14 April 2026

SSD 96505456
DA479/25
JD6 (P&E)

**STATE SIGNIFICANT DEVELOPMENT APPLICATION 96505456
19-23 ROSALIND STREET CAMMERAY
SENIORS HOUSING
PERIFA ROSALIND DEVELOPMENT PTY LTD**

DRAWING TITLE
LOWER GROUND - PROPOSED PLAN
 DRAWING NUMBER
 DA-101
 REVISION
 A

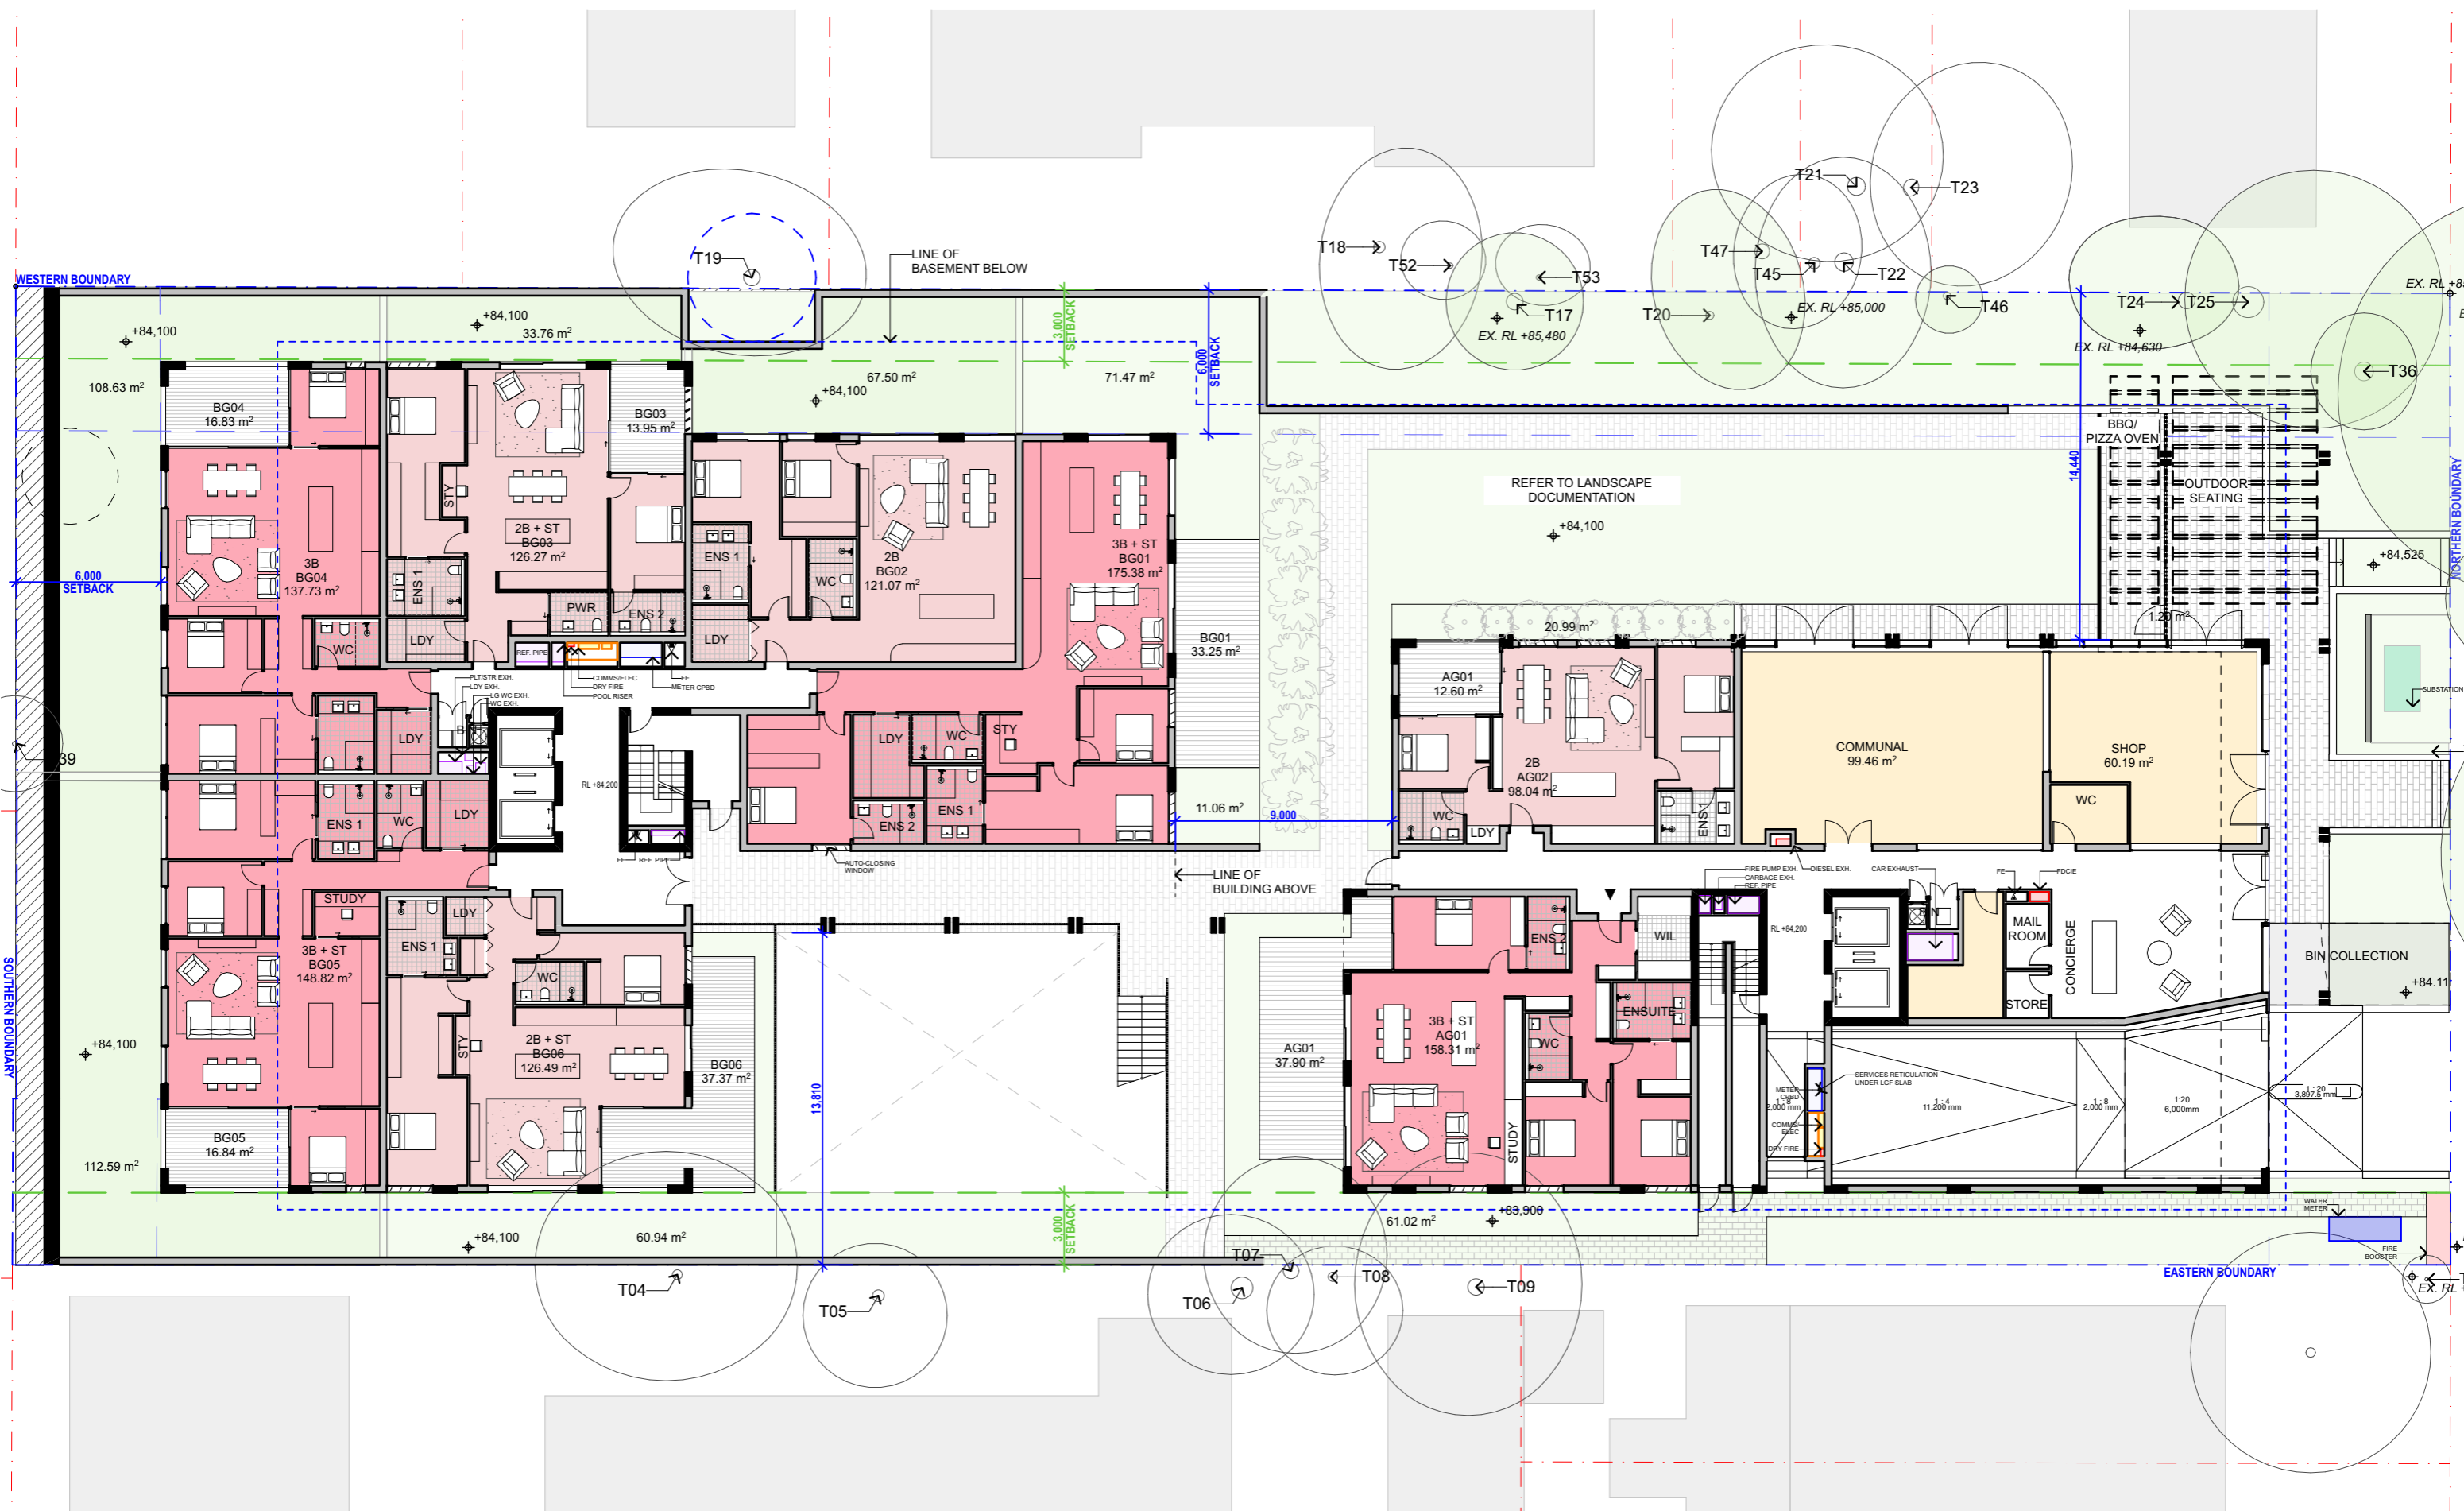
- A two room residential care facility (commonly known as a nursing home, according to baptistcare.org.au), located on the lower ground floor, and
- 49 independent living units, in two buildings on ground level and all levels up to level 5.

The proposed facility's location is in the basement, on the southern side of a sunken garden, approximately five metres below existing ground level. The two rooms in the facility face this space, which cannot be readily seen by residents of the two rooms, as it is screened by dense landscaping for privacy, paradoxically reducing already poor amenity.

Neither is the facility likely to satisfy requirements as a healthy, pleasant workplace. Even with artificial lighting and high-energy-using air conditioning and mechanical ventilation, the space will likely be damp and unhealthy for most of the year. In mid-winter the facility would receive no direct sunlight between 9.00am and 3.00pm, according to submitted shadow diagrams.

4. *Should the application be amended to provide a genuine residential care facility, its siting and location should be suitable for its intended use. Any habitable space below existing ground level should be removed from the proposal, or relocated above ground, with reasonable and suitable amenity for all habitable spaces, indoors and outdoors, for residents and staff.*
